**CITY OF ALBUQUERQUE
PLANNING DEPARTMENT
January 22, 2014
DRB Comments**

PROJECT # 1009840

RE: Lot 31, Block 3, North Albuquerque Acres Tract 3 Unit 3

PROJECT #: 1009840  
 DATE: 1-15-14  
 APP #: 14-10002 (P) & 14-10004 (S) & 14-10004 (S) & 14-10004 (S)

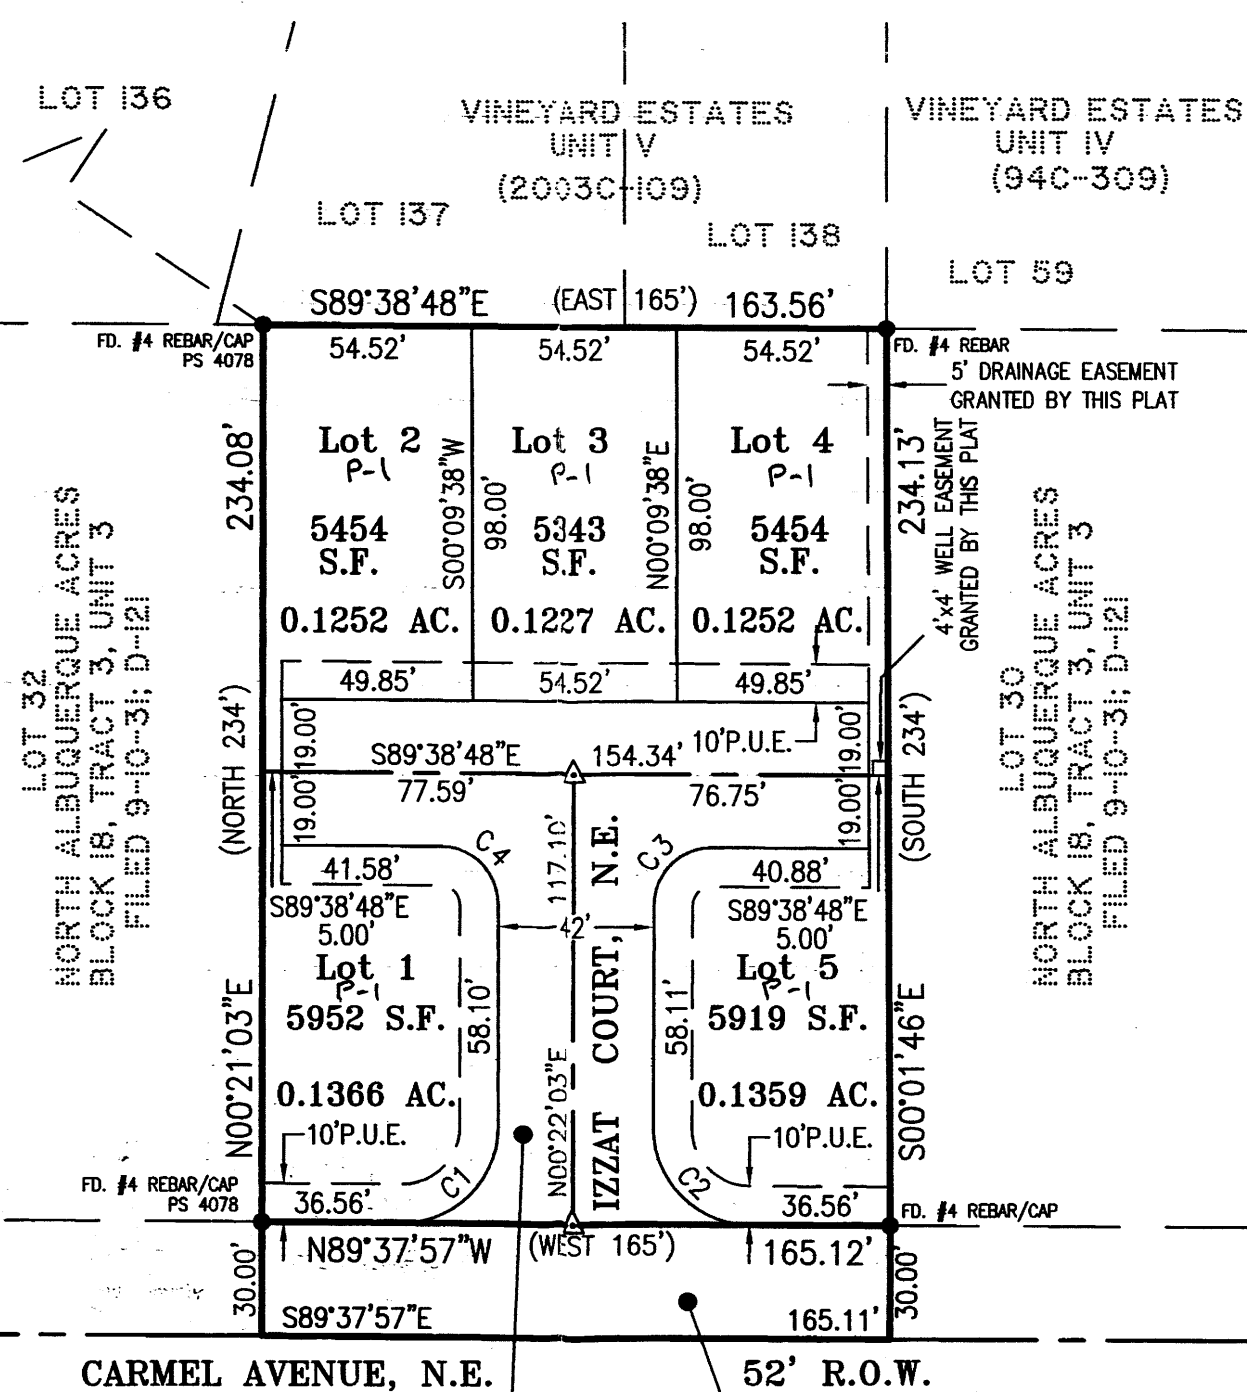
The Planning Department would consider a modified Design Variance for reduced right of way/ sidewalk setback from the curb of 4 feet.

A recorded Subdivision Improvements Agreement/ SIA or completion and acceptance of infrastructure is required for Final Plat. Please remove Zoning Note (No. 5) from Final Plat.

Please note that maximum wall height in a residential zone is 8 feet; clear sight triangles need to be demonstrated.

PROJECT #: 1009840
 DATE: 1-15-14
 APP #: 14-10002 (P1A)
 14-10001 (SN)

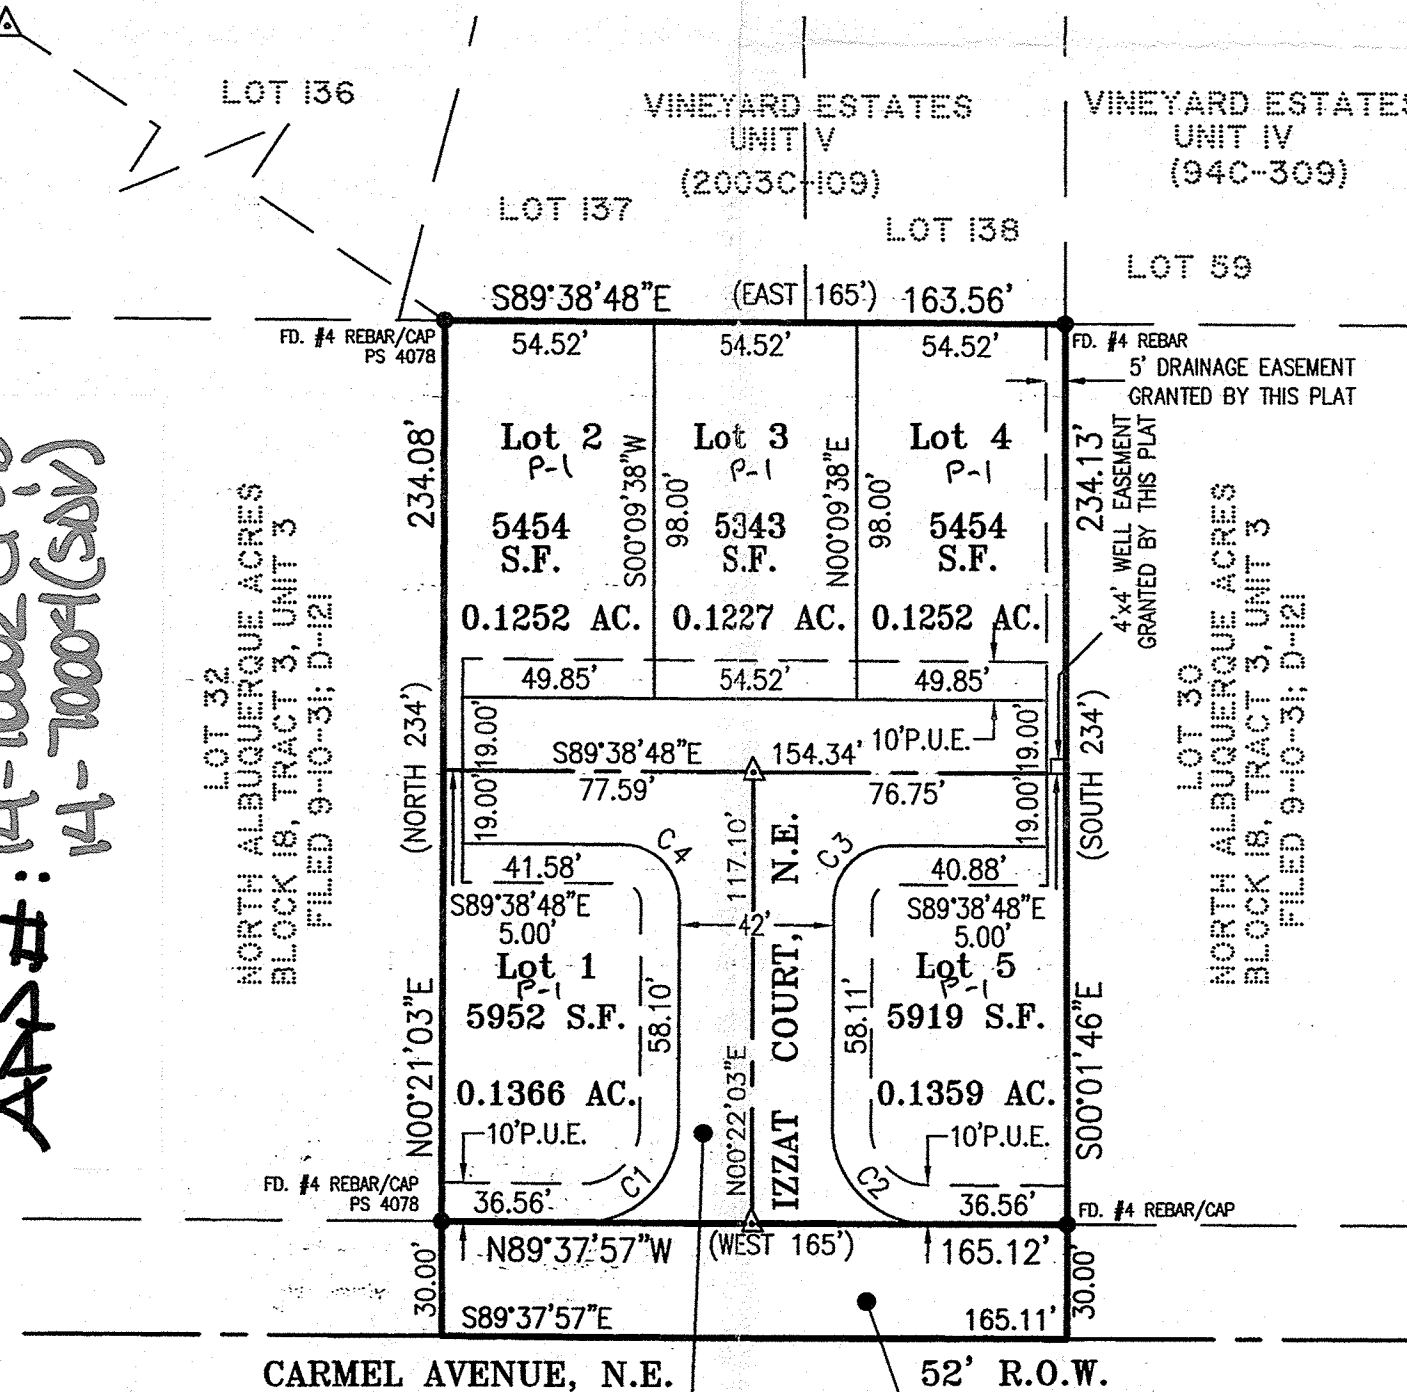
The proposed Design Variance does not appear to be in accordance with accepted principles of site planning for equitable pedestrian access. The Planning Department would consider reduced right of way to minimize sidewalk setback from the curb and allow two sidewalks back to the turnaround.

A recorded Subdivision Improvements Agreement/ SIA or completion and acceptance of infrastructure is required for Final Plat. Please remove Zoning Note (No. 5) from Final Plat.

Please note that maximum wall height in a residential zone is 8 feet and minimum pilaster projection is 2 inches; clear sight triangles need to be demonstrated.
